**RE: Australian Institute of Nanoscience and Research Education Facility,
The University of Sydney – SSD 5087-2011**

As delegate of the NSW Heritage Council, and in accordance with the Heritage Council's advice, the Director of the Heritage Branch therefore recommends to the Department of Planning and Infrastructure that the application for the Australian Institute of Nanoscience and Research Education Facility development application SSD 5087-2011 be deferred for receipt of the following information:

Figure 7 Visual Impact of the proposed AIN Building.

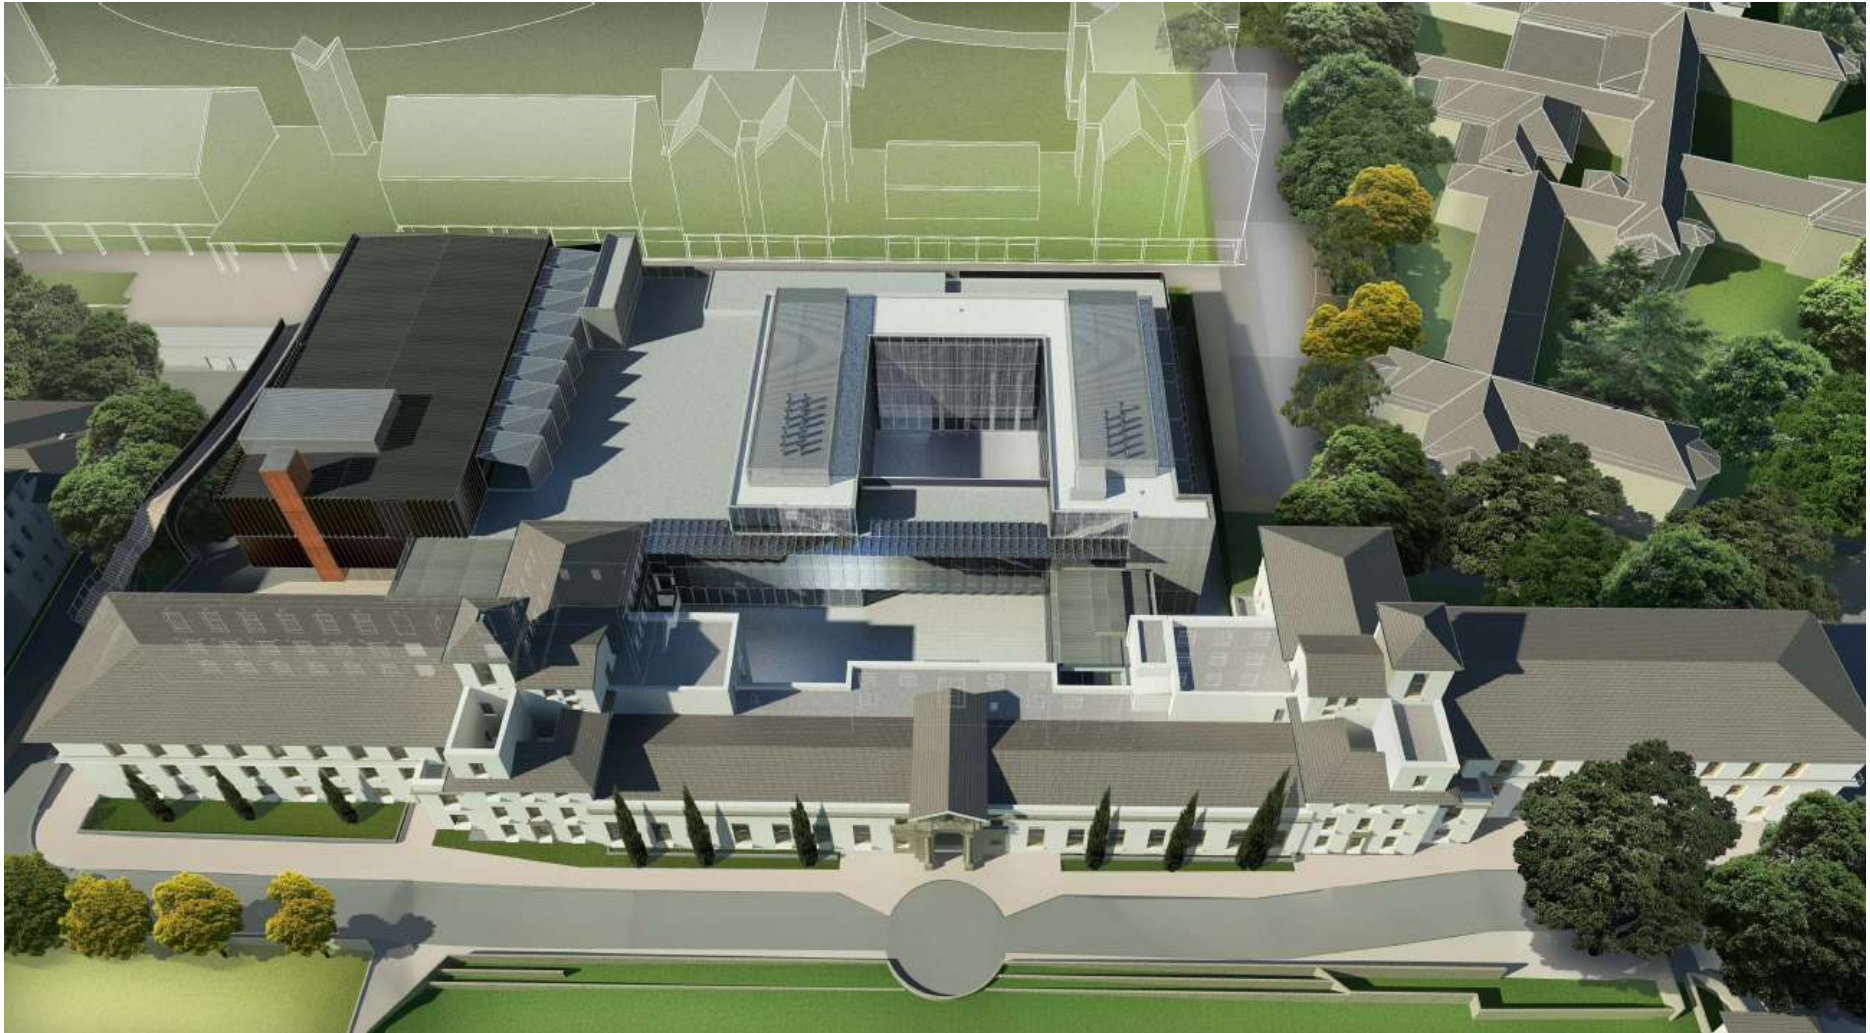
However, both development applications and their potential impacts are being assessed in isolation and the photomontages submitted with the AIN application do not accurately depict the extent of trees proposed to be removed in the St Paul's master plan.

- c) **Provide a photomontage from the Education Building of the Physics Building, which accurately depicts the extent of trees proposed to be removed and buildings constructed in the St Paul's master plan that would form a background to the proposed Australian Institute of Nanoscience and Research Education Facility.**
